PLANNING CONSULTATION RESPONSE

Application No	2025/0775
Proposal	Development of 4 residential dwellings, landscaping and associated infrastructure
Address	Land east of Bank View, Bower Hill Road, Oxspring, Sheffield, S36 8YA
Date of Consultation Reply	08/12/25
Consultee	Nik King, Senior Urban Design Officer

These are the second set of design comments, in the light of revised drawings and an accompanying email received from PB Planning, dated 18th November 2025.

PROPOSED SITE PLAN

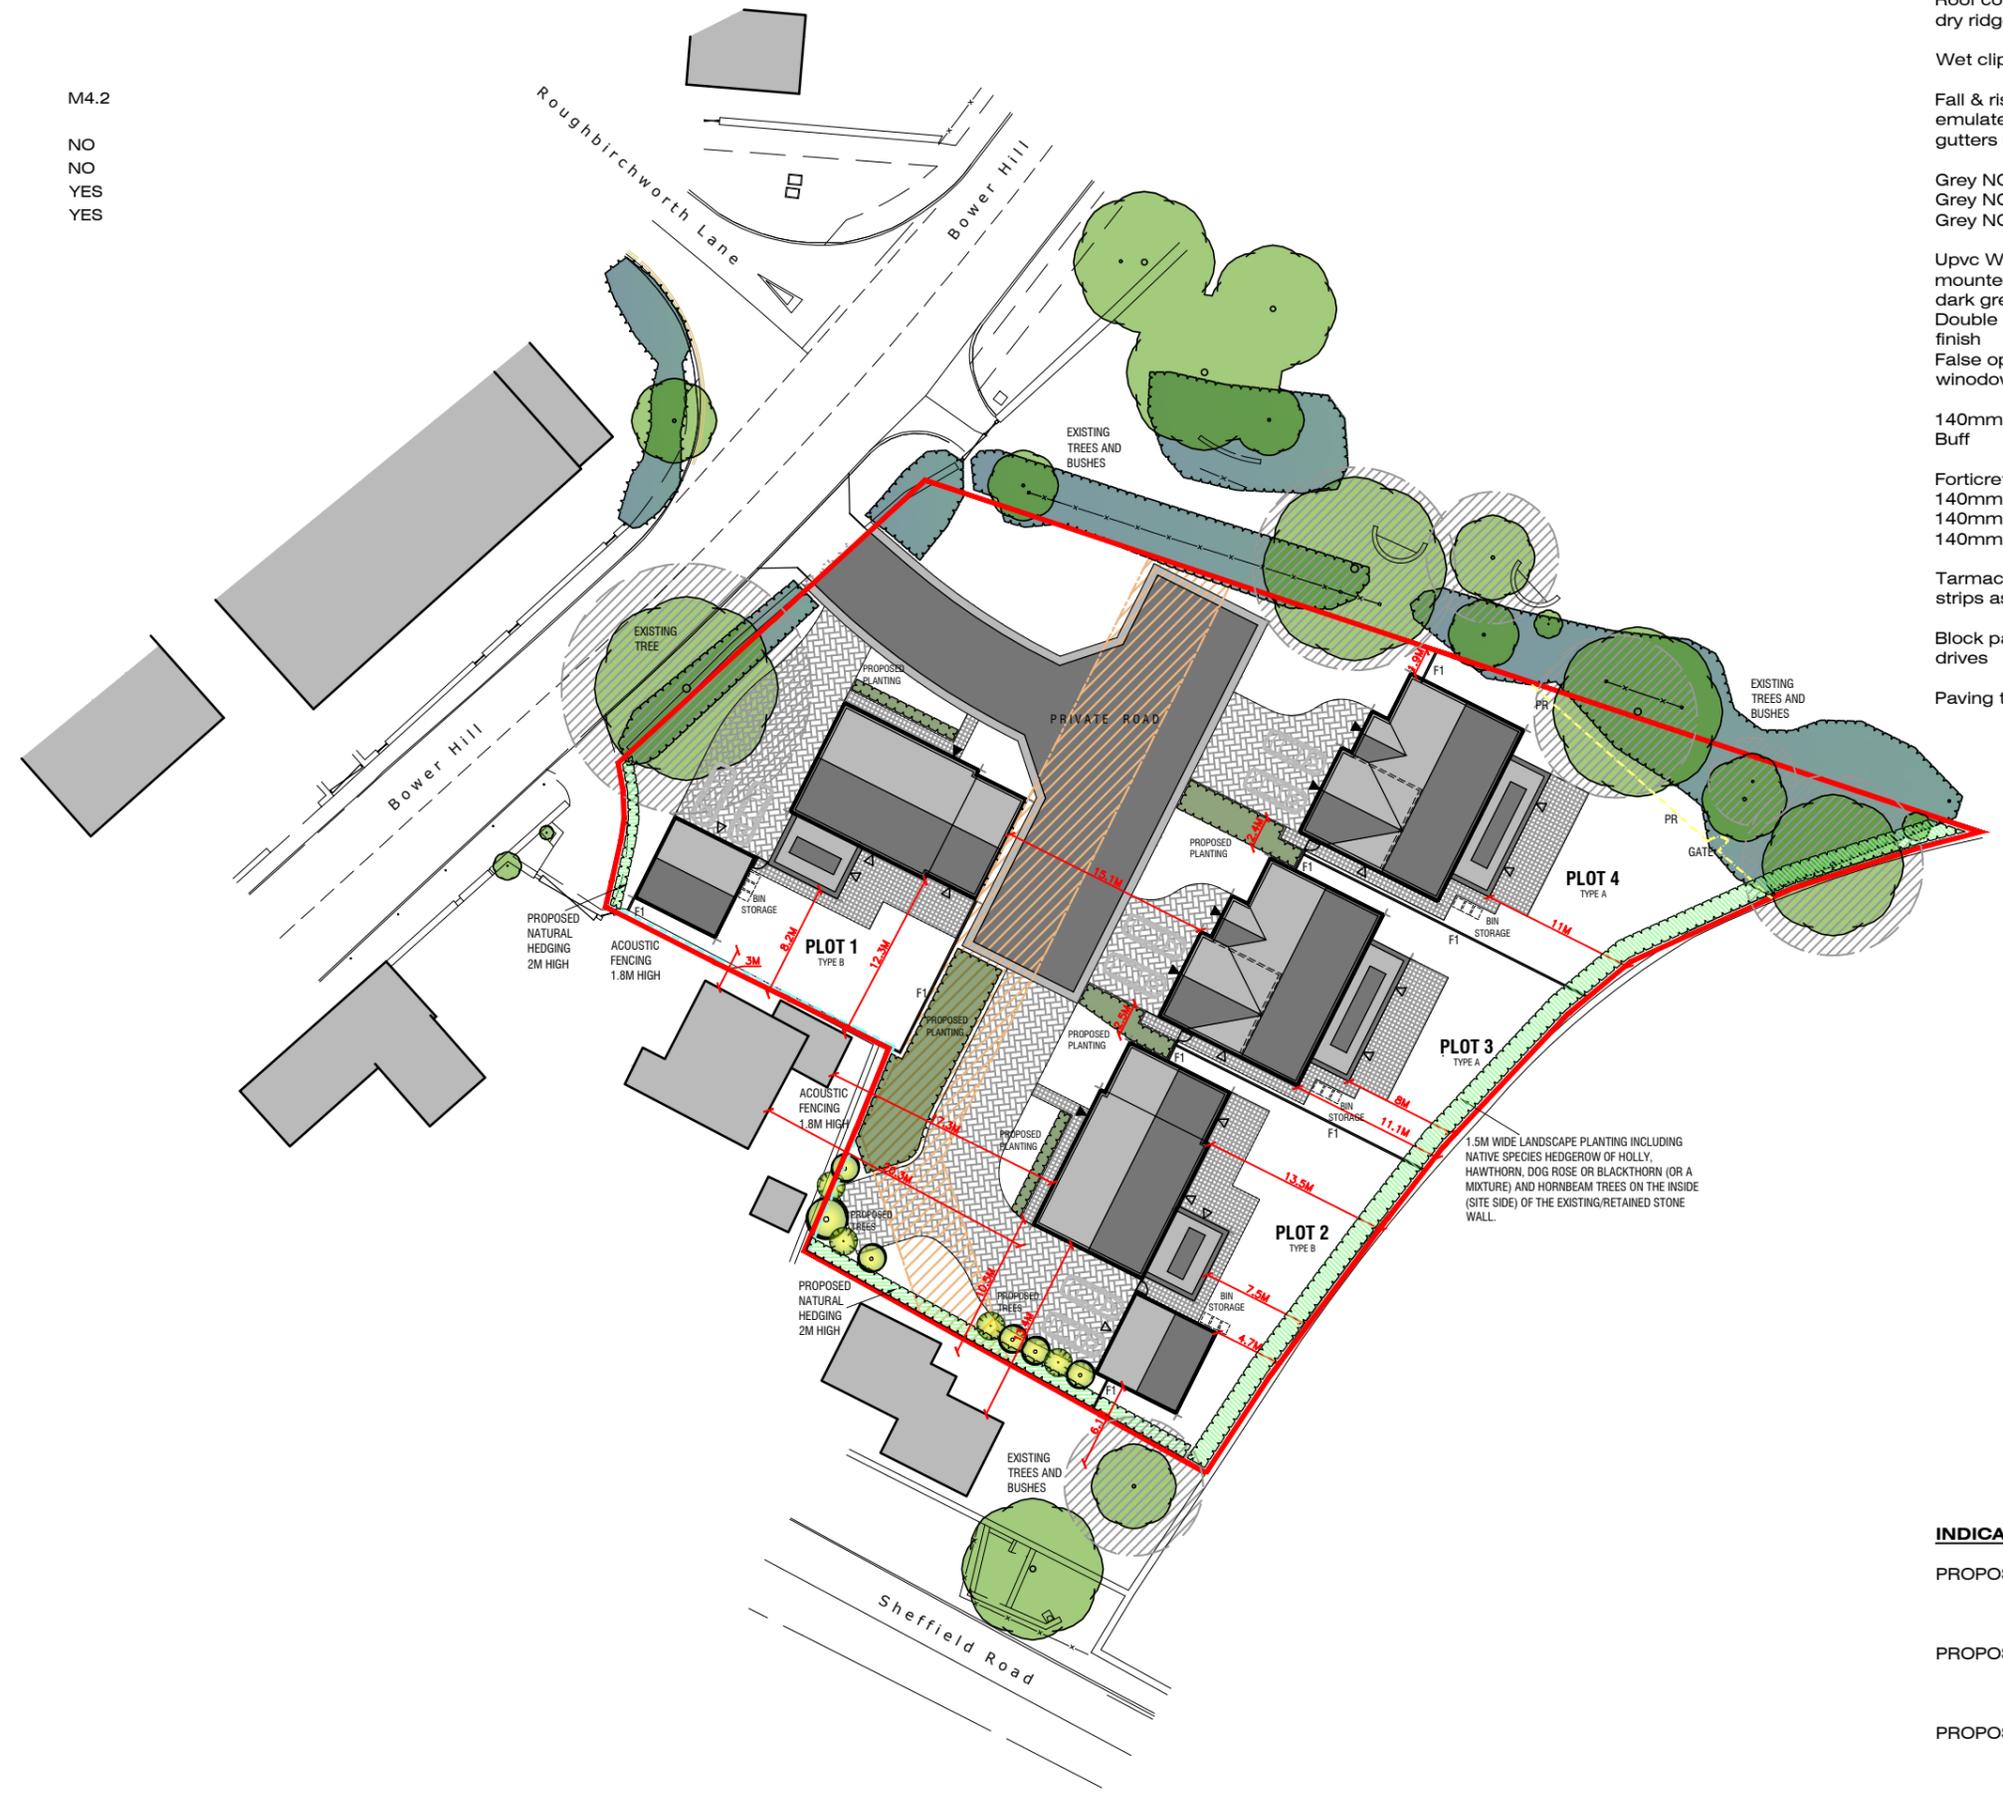
Most of the additional information required can be dealt with by condition but I would suggest that for the 'Proposed Site Plan' that the annotation for the '1.5 m wide landscape planting....' For the south-eastern boundary of the site, is amended to include the wording 'at least 2m high'. (The height annotated for the other natural hedging shown on the boundaries of the site is 2m). I think the height of this hedge is an important component of the proposals and would suggest this is made clear, for the benefit of all parties, prior to the determination of the planning application.
